Silverleaf Solar Farm (SSD-9358) – Response to RFI-39195709

Attachment 1 – Updated intersection design including Basic Left Turn (BAL)

Client	NSW GOVERNMENT
Project	NARRABRI SOLAR FARM SILVERLEAF
Title	KAMILAROI HIGHWAY / LOGANS LANE INTERSECTION UPDGRADE - BAR ONLY OPTION
Original Size	A1
Drawing No:	22-12518304-SK003
Rev:	C

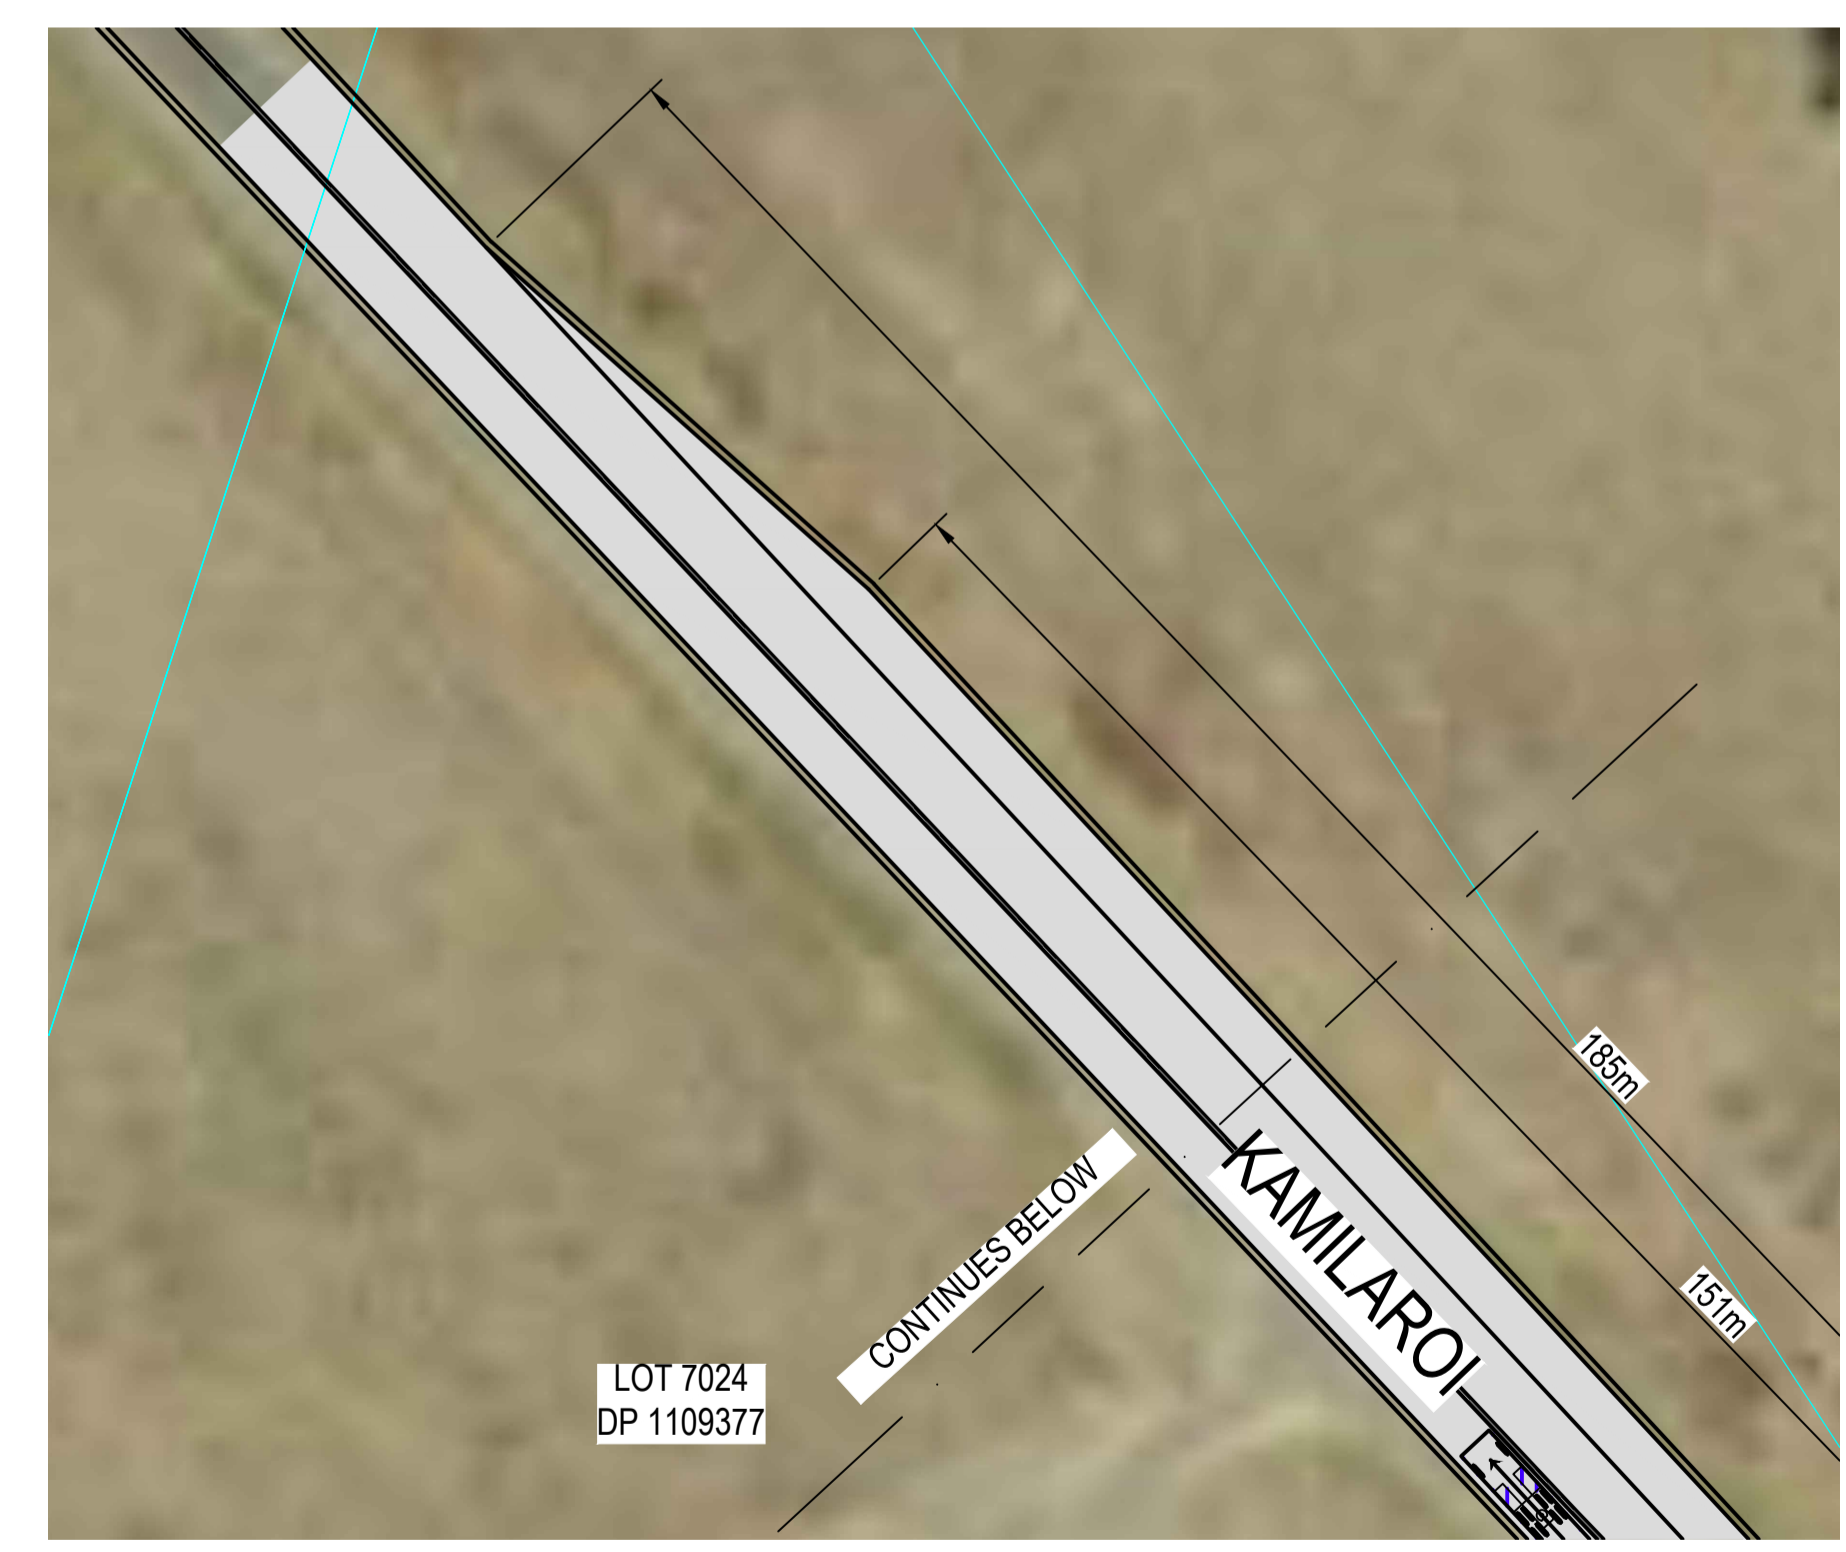
- Has revised drawings for the treatment of intersection of Kamilaroi Highway and Logans Lane, incorporating a Basic Left Turn (BAL) treatment (Attachment 1).
- Confirm that this revised intersection treatment will not have additional impacts on native vegetation or heritage.
